KITTITAS COUNTY

MEMORANDUM

TO: All Staff
FROM: Public Works Plan Review Team
DATE: May 31, 2024
SUBJECT: BL-24-00008 Palmer

RECORD OF SURVEY

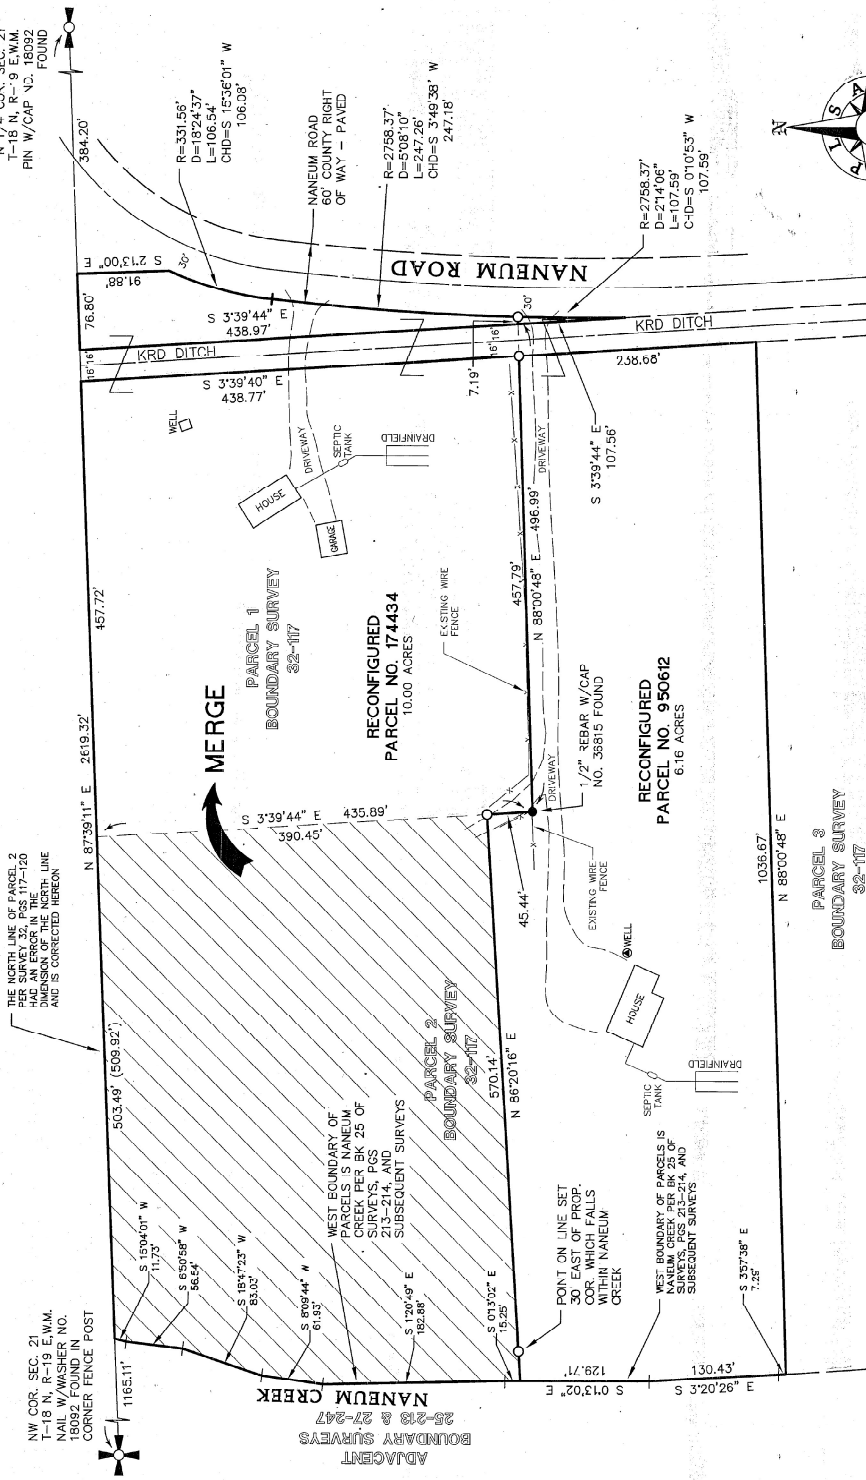
SURVEY	<p>As the application deos not contain a survey map, comments are reserved until final. (JT)</p> <p>UPDATE 07/23/2024</p> <ol style="list-style-type: none">1. Include a title at the top of the page including "Record of Survey, Pt of NW1/4 of NE1/4 T18N., R19E., W.M., Kittitas County, Washington"2. Label full right of way width, ownership and surfacing for Naneum Rd. (EX: Naneum Rd. 60' County R/W – Paved)3. Show the 3 dimensions of the little sliver of land for that portion of Parcel 950612 lying East of Naneum Road.4. Include a "purpose of survey statement" similar to the following: The purpose of this survey is to identify the parcels and satisfy the conditions of

<p>approval for a boundary line adjustment submitted to Kittitas County under application No. BL-24-00008.</p> <p>5. Please identify the West line of the survey as “West Boundary of Naneum Crk.” (per Sur:25-213, and subsequent surveys)</p> <p>6. The title report provided in the application does not match the area surveyed. A correct title report will need to be provided prior to final approval.</p> <p>OF NOTE (Changes not required)</p> <p>1. A lot closure report was not provided, nor were lot closures reviewed. Given the simple nature of this BLA, closures are not required.</p> <p>2. The North line of the transfer parcel does not match Survey: 32-117. While Survey 32-117 appears to be incorrect, the distance discrepancy could be noted, depending upon the surveyors interpretation of WAC:332-130-050(1)(f).</p> <p>3. Due to wrong title report being submitted, existing legal descriptions have not been compared to title documents. (JT)</p>
